RE: 1321 & 1325 Van Cleave Rd. NW
Grading and Drainage Plan
Engineer's Stamp Date: 02/22/23
Hydrology File: G13D043

Based upon the information provided in your submittal received 02/28/2023, the Grading & Drainage Plan is approved for Grading Permit (earthwork can get started for the earth pad on the house).

HELLER, ADAM - GRADING & DRAINAGE PLAN

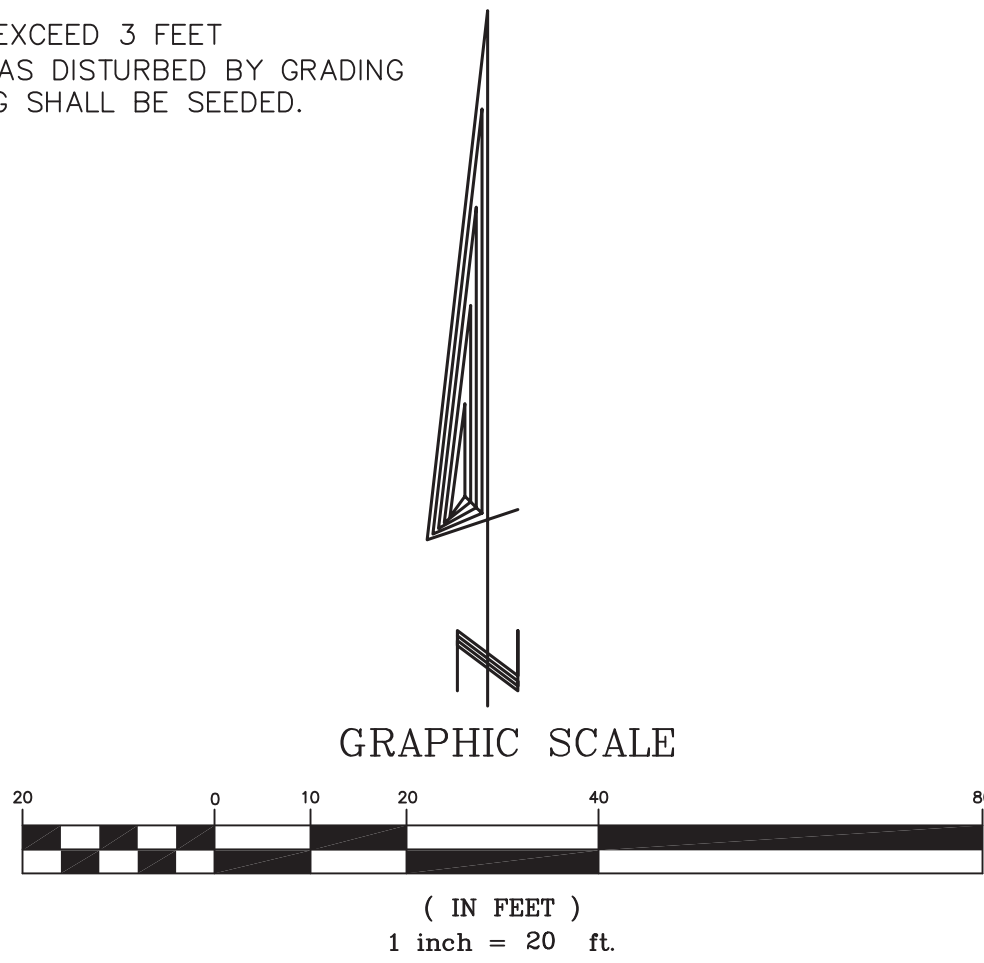
1. Once the grading is complete, a pad certification (meaning that the earthwork is complete) will be required. **Please include a site photo with the submittal.** Also, at the time of pad certification approval, Hydrology will concurrently approve the Grading & Drainage Plan for Building Permit.
2. Please show that the two existing drive pads are being replaced with new curb & gutter and sidewalk.

3. Also, please separate the two since there will be two separate Building Permits pulled. Please just place a big "X" over the lot that does not go with each address.
